WEST SUSSEX COUNTY COUNCIL CONSULTATION

TO:	Arun District Council FAO:
FROM:	WSCC - Highways Authority
DATE:	16 April 2020
LOCATION:	Riverside Industrial Estate, Block T Bridge Road Littlehampton BN17 5DF
SUBJECT:	LU/50/20/PL 4 No. Industrial Buildings (B1, B2 & B8 uses).
DATE OF SITE VISIT:	n/a
RECOMMENDATION:	No Objection
S106 CONTRIBUTION TOTAL:	n/a / £ See below for breakdown.

PROPOSED SITE PLAN

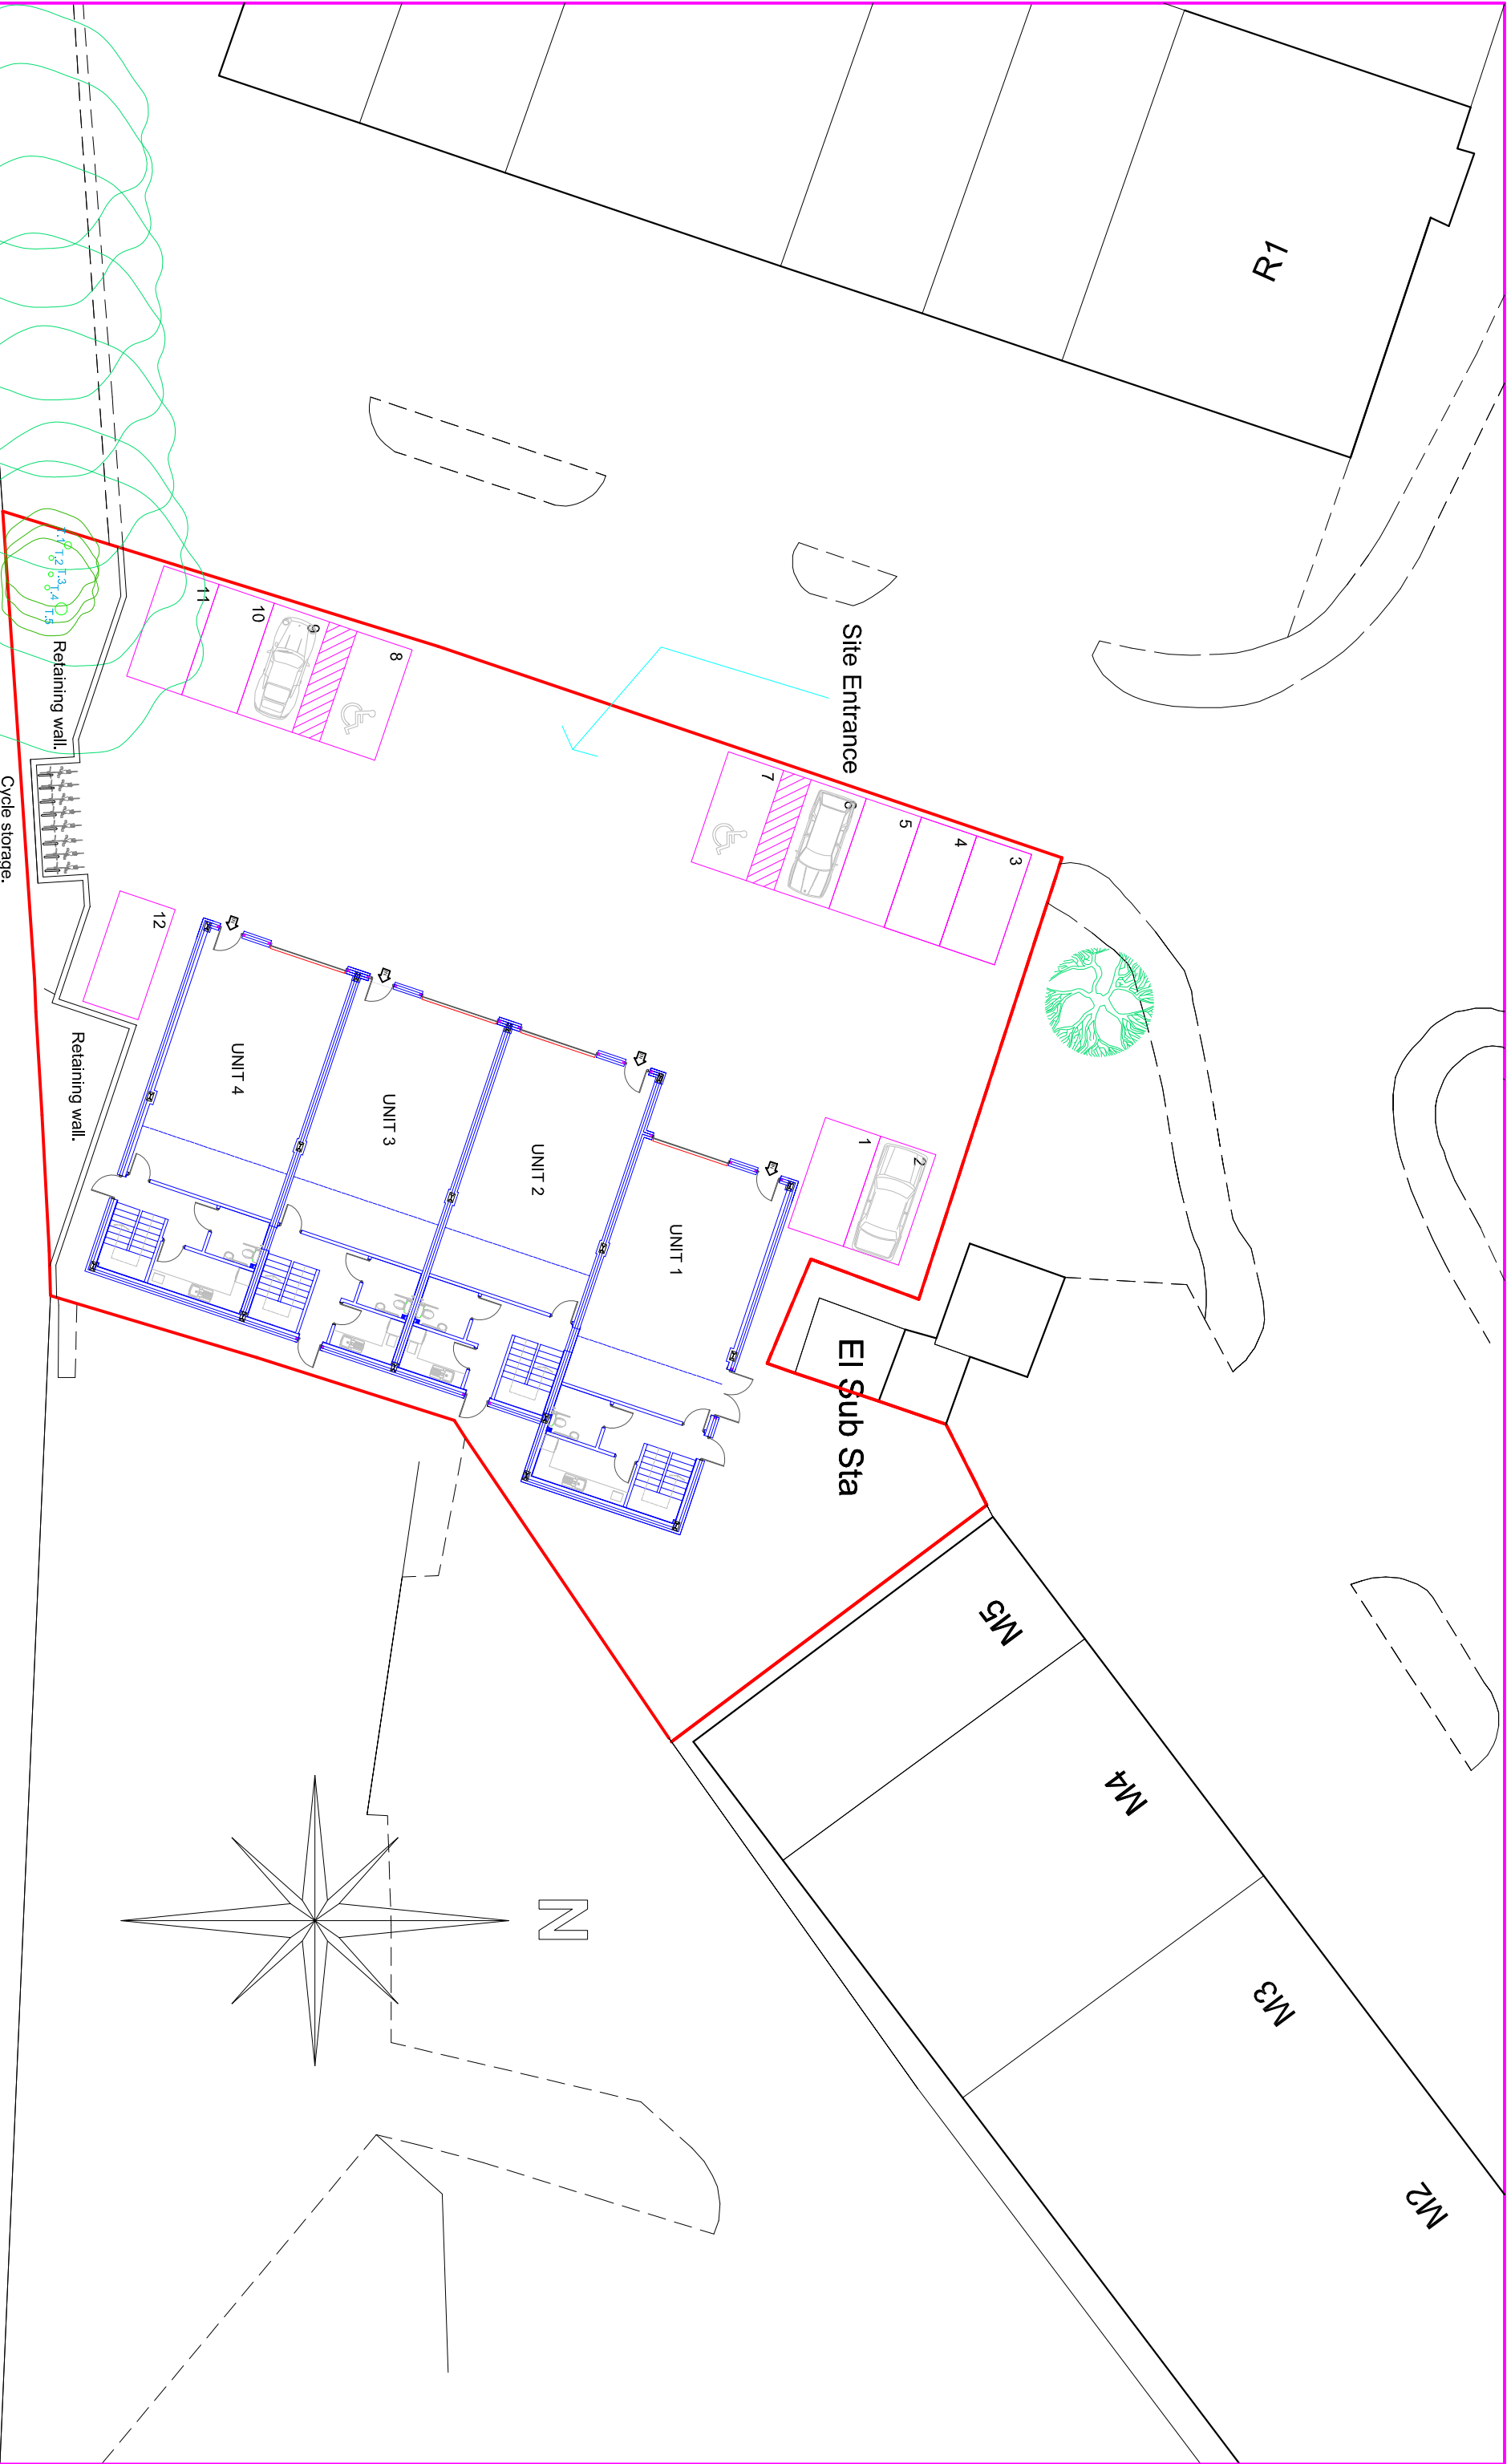
Given the small scale of this proposal the net increase in trips to and from the site is likely to be immaterial in planning terms. Car parking for the use has been provided, and offers 12 spaces, 2 of which are for disabled use, which is in line with Manual for streets guidance of at least 5%. WSCC guidance on parking at new developments 2019 has been consulted and a B2 use class commands 1 space for every 40sqm which equates to 12 spaces. The only parking not allocated is staff parking.

WSCC would recommend the applicant should try to accommodate all its parking needs within the site, as the additional requirement is just two more spaces. Tandem spaces for staff could work in this scenario. Of course if this cannot be provided then it is acceptable for two spaces to find a parking space within the industrial estate roads.

The site is in a sustainable location, close to rail and bus transport. The applicant has also provided cycle storage which should be covered and secure.
